Subject: FW: 1120 Fleurie Nursery - Lake Lane WA/16/21/DOC

Subject: 1120 Fleurie Nursery - Lake Lane WA/16/21/DOC

Thanks for sending through the submitted plant schedule for the Native hedge and Native Copse Woodland Planting mixes.

PROPOSED
Landscape Plan
1120 - 010
February 2021
1500 @A3

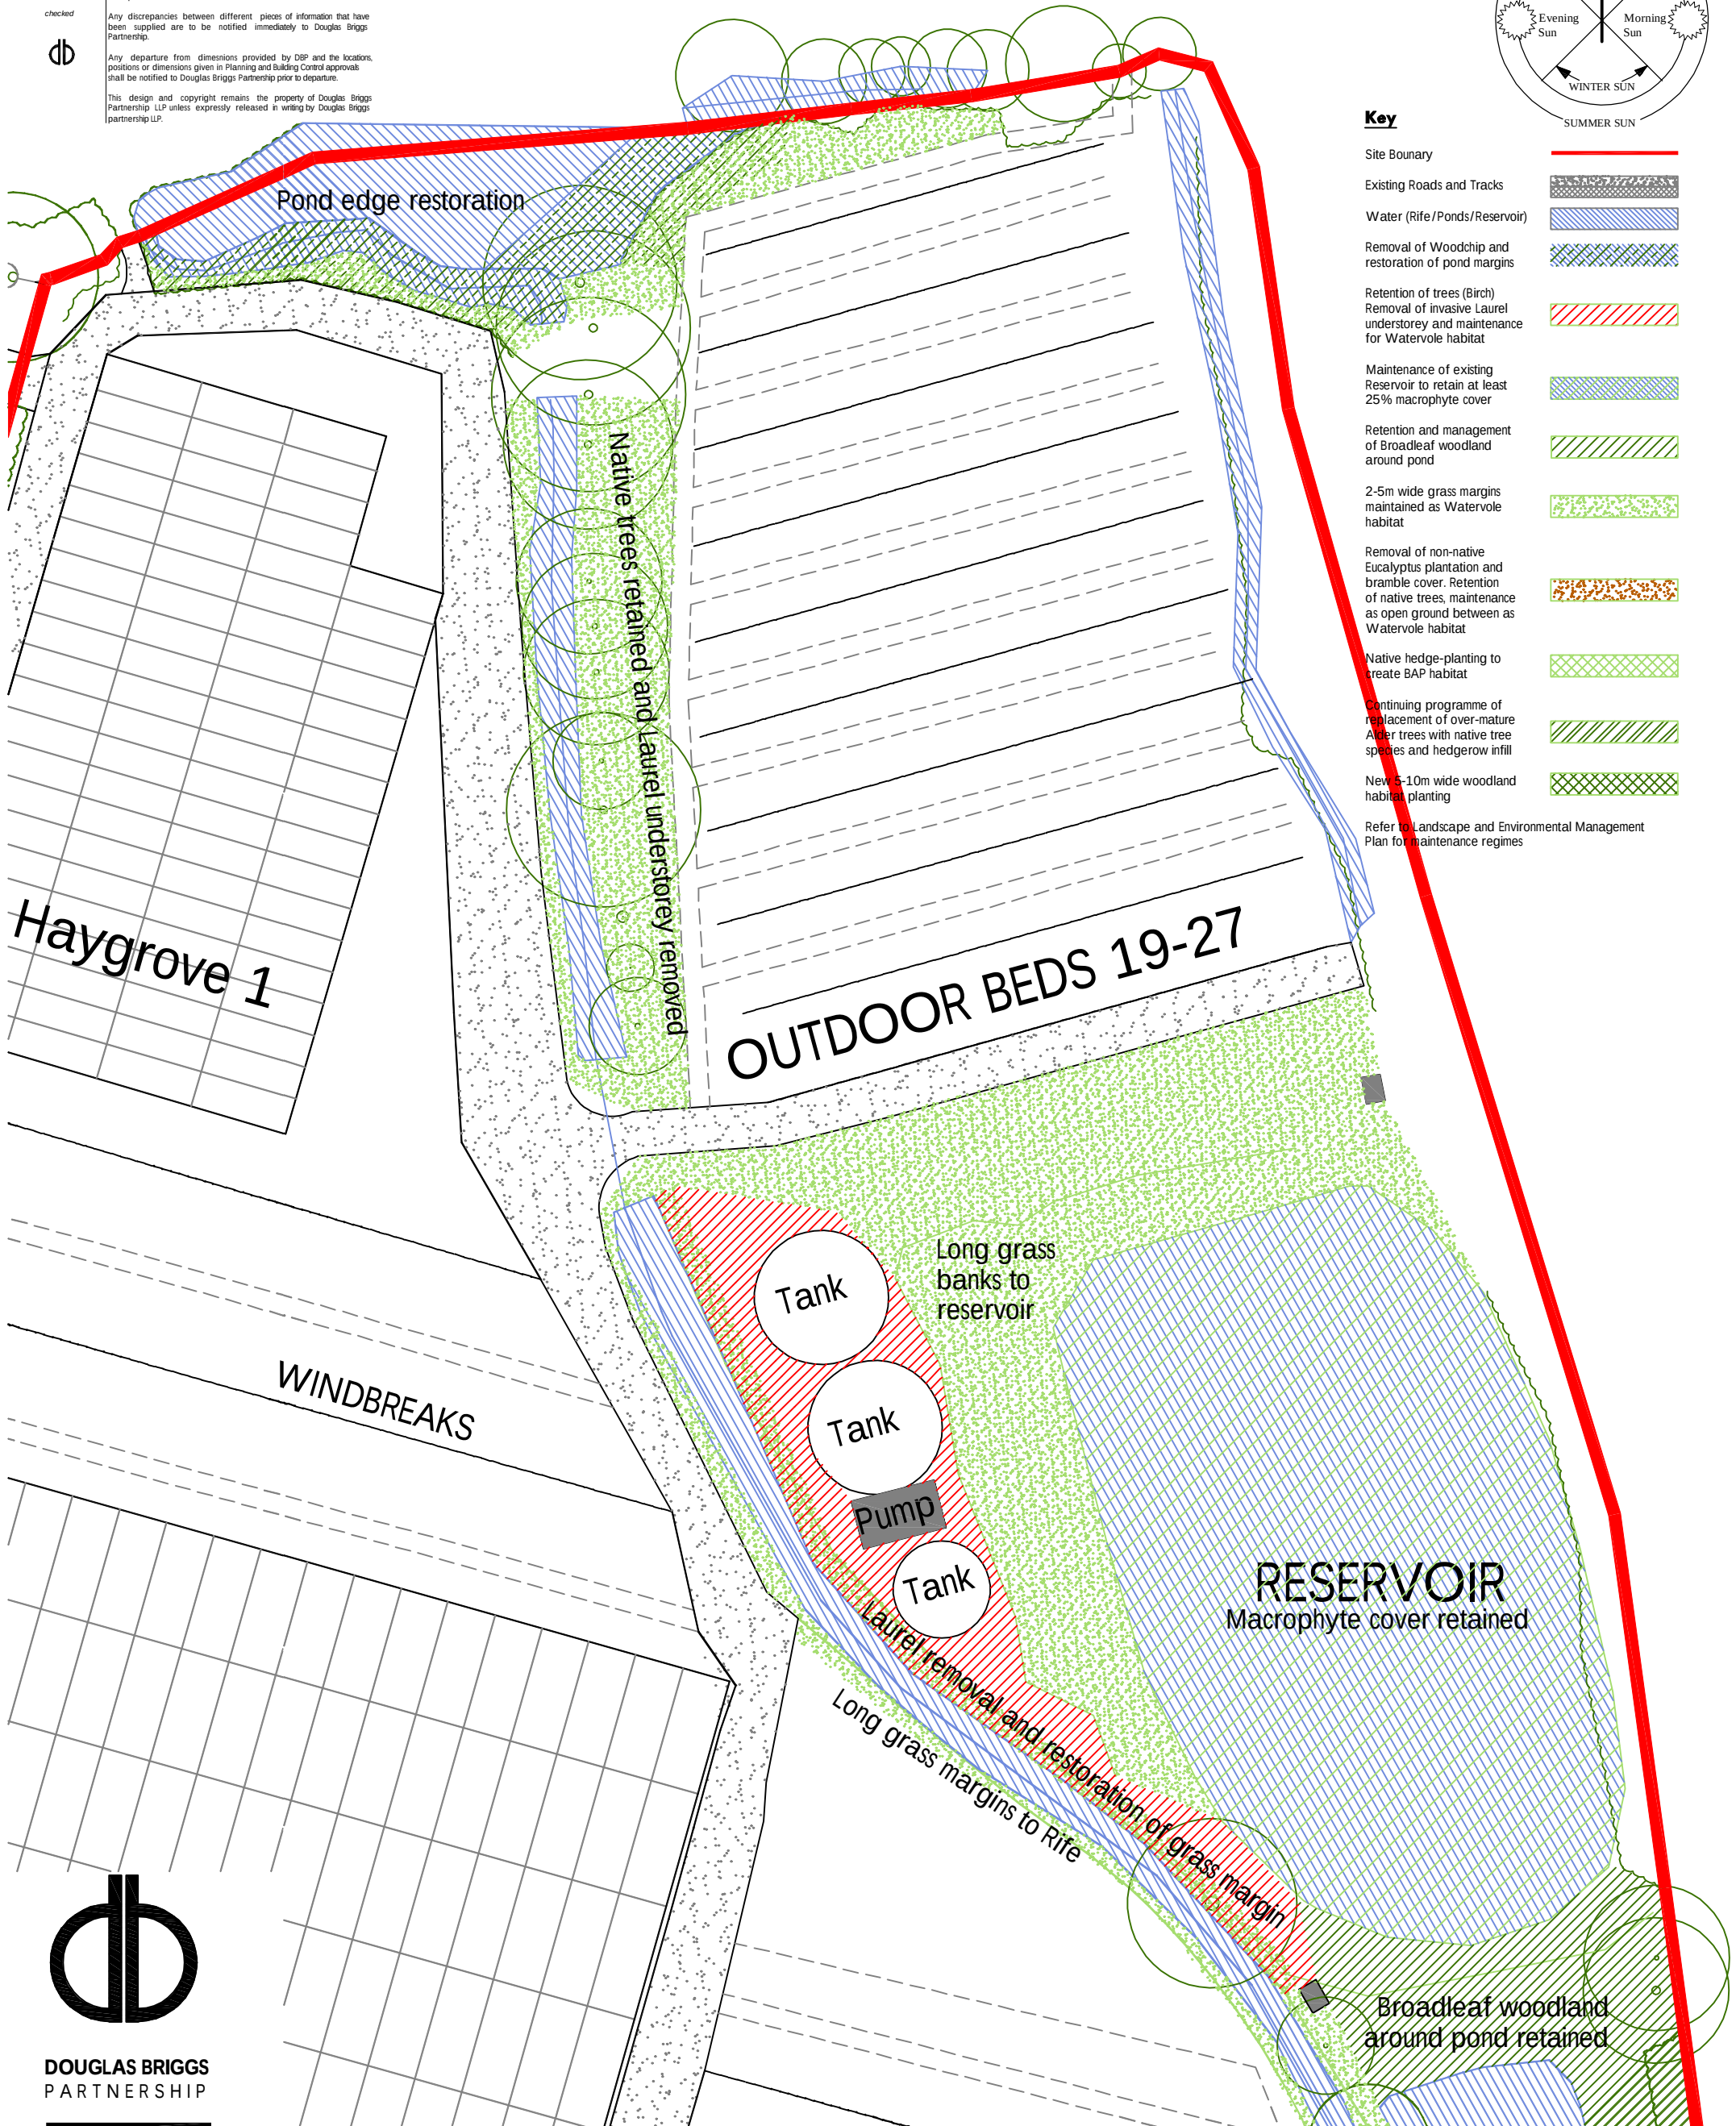
The information has provided further clarity, but in order to be able to recommend discharge of Condition 9, detail in plan form re quantities still needs to be provided. ie actual quantities for the new hedges (appreciate more difficult to show for the gapping up) The information also needs to be shown in plan form ie plant numbers in location. (see extract from consultation below)

Further detail is requested to confirm the plant quantities for these areas and anticipated gapping up numbers. The detail is required to be shown on the submitted drawings and needs to show clearly quantities, species mix i.e. percentage of each within the species mix, planting densities (anticipated in gapping areas) and size of plants at time of planting.

Happy for this information to be hand annotated onto the drawing.
